App no: 22.0568

Address: Land to rear of Malt Kiln House Malt Kiln Brow Chipping

Proposal: Four new, two-storey residential dwellings

The amended plans and documents named 'Traffic Management Plan' MKB/P03 Rev C' dated 02.12.2022 and 'Construction and Environment Management Plan' have been reviewed.

PROJECT				
Proposed Residential Development at Malt Kiln Brow, Chipping.				
DRAWING TITLE				
Traffic Management Plan.				
DATE	SCALE	DRAWN	DRWG No.	REV
June 2022	1:500 @ A3	SDH	MKB/P03	C

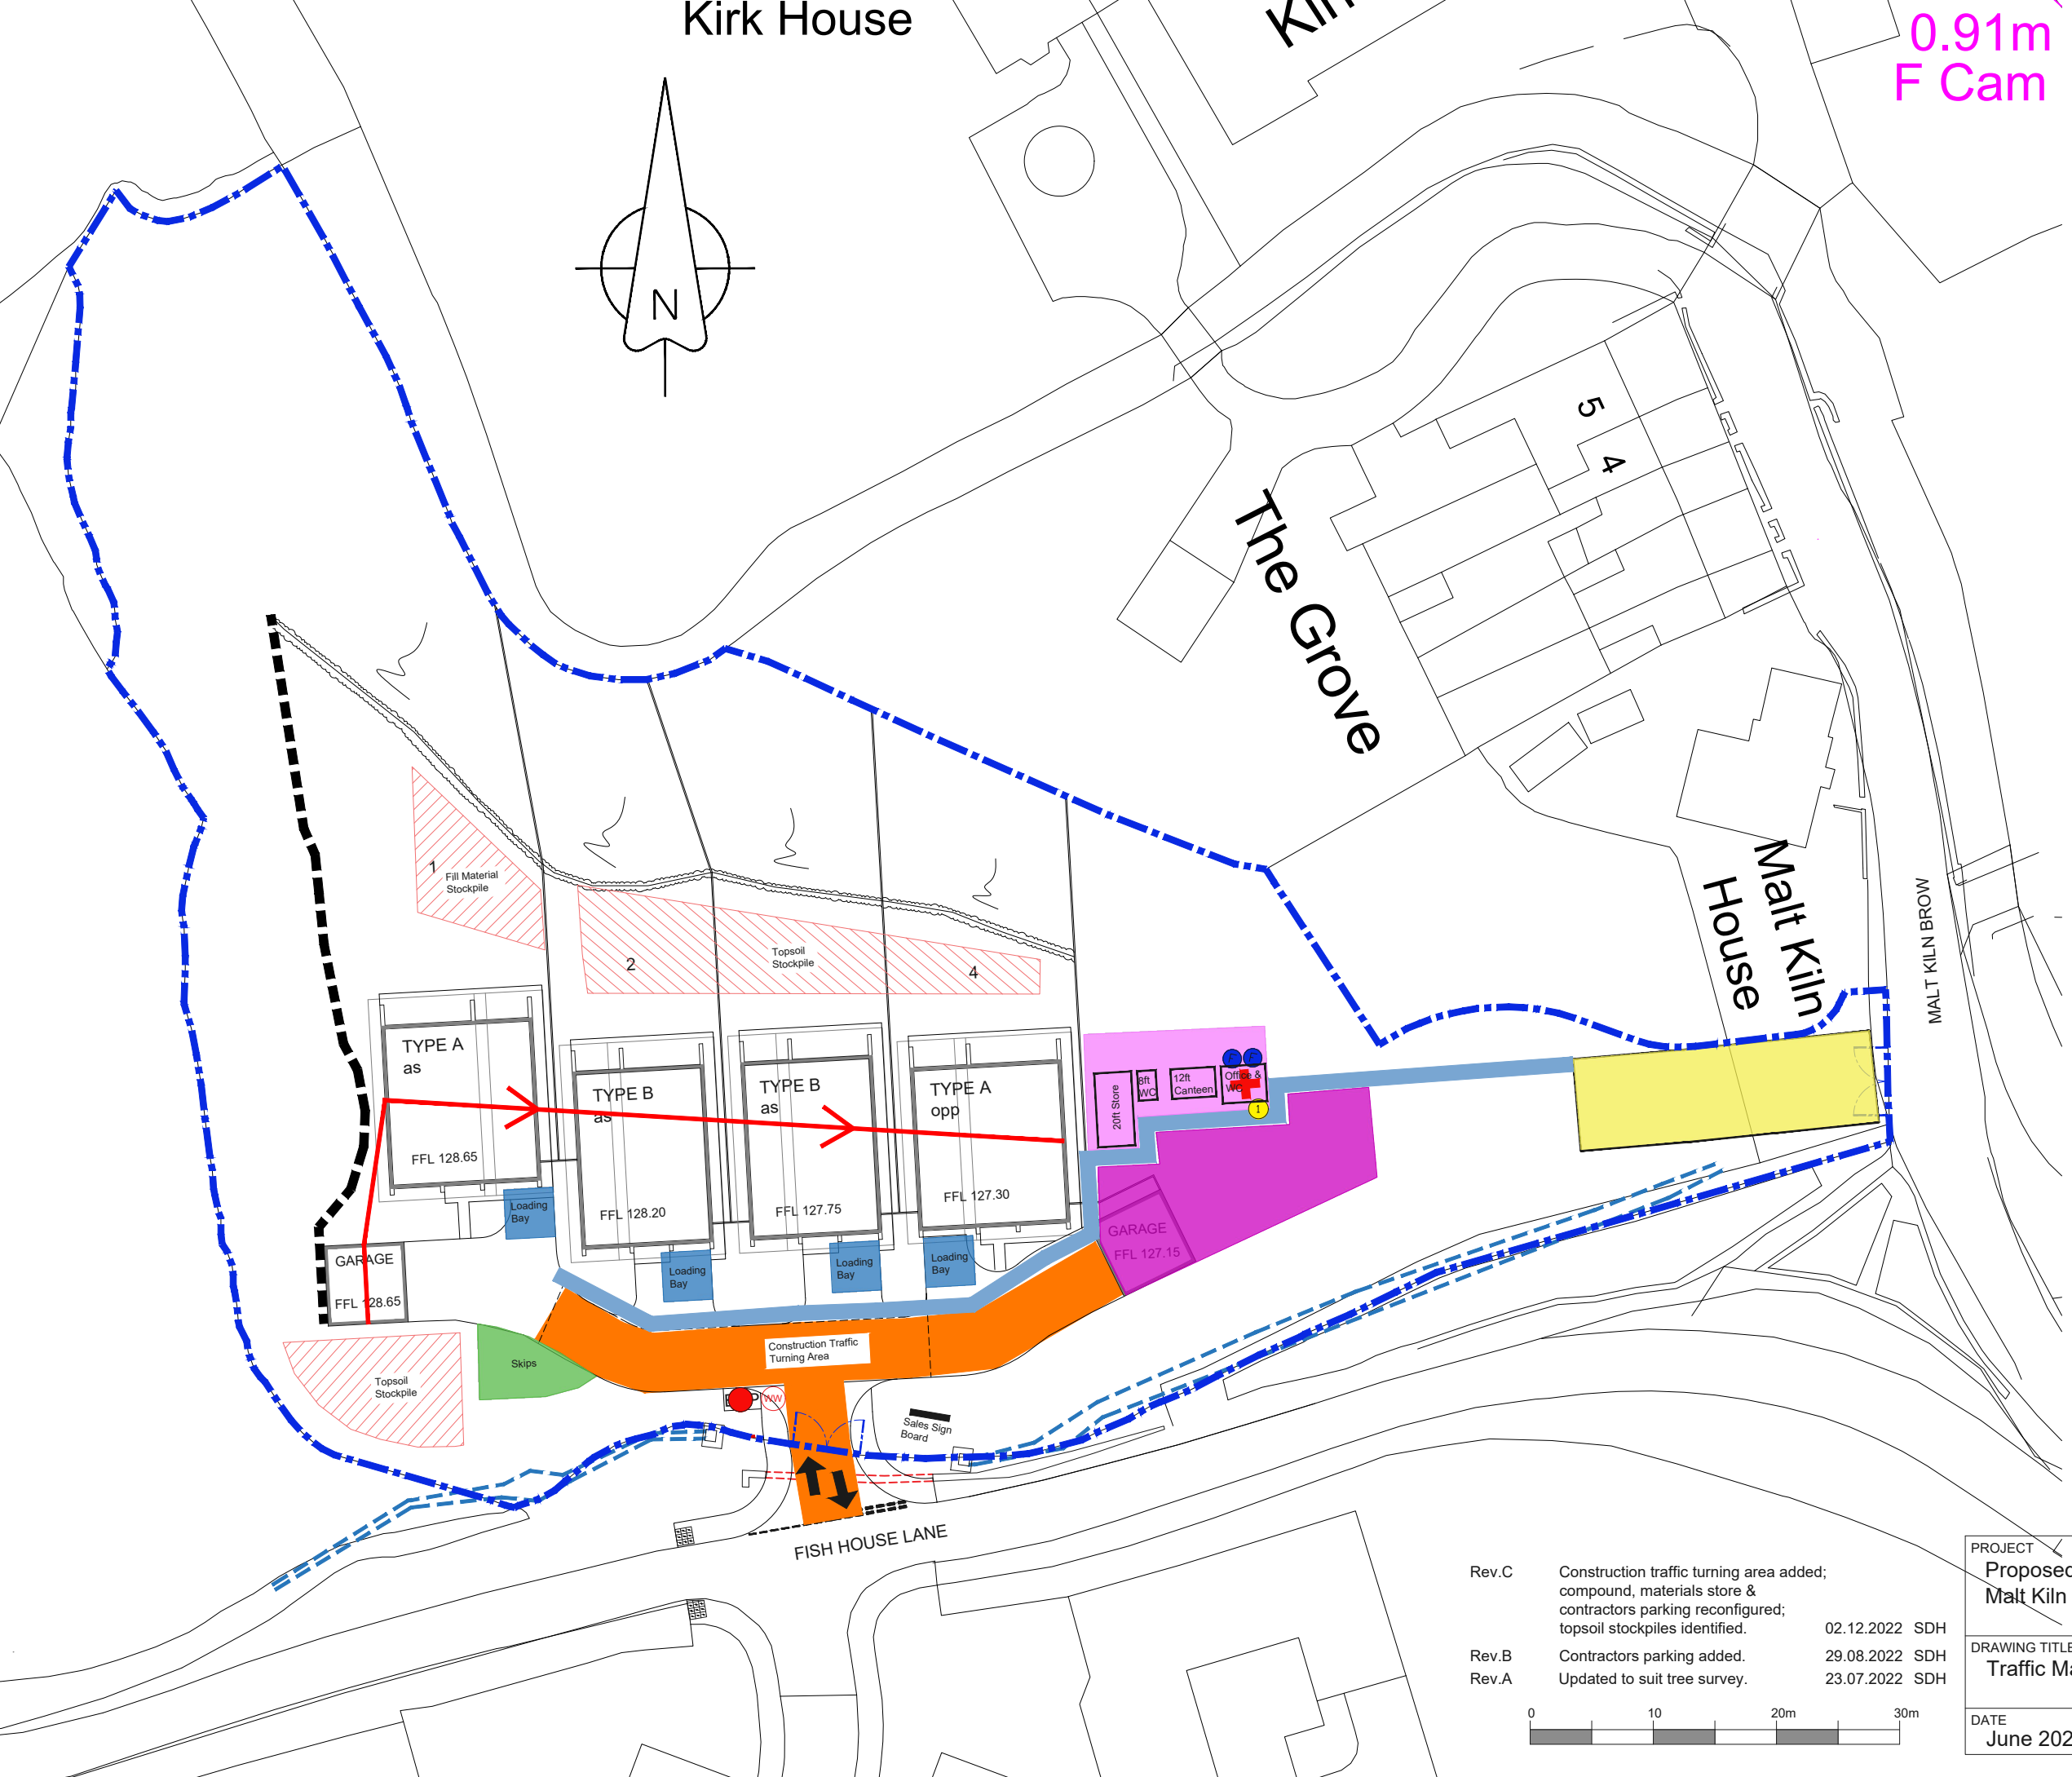
The revised plans amend the access arrangements for construction delivery vehicles. The proposed site access on Fish House Lane will provide a single two-way access for vehicles with an internal turning and storage area.

Access, parking and turning for contractors/operatives vehicles will be provided separately via the previously approved access on Malt Kiln Brow. The area shaded yellow measures approximately 7.5m by 24.5m which is insufficient to provide parking and turning for more than a few vehicles. Operative parking has been a concern previously and overspill onto Malt Kiln Brow and Fish House Lane is not supported by the Highway Authority due to conflict with pedestrians and other highway users due to lack of footways and restricted carriageway widths. Revision B provided 8 operative car parking spaces therefore more information is requested to show a suitable provision for operative parking.
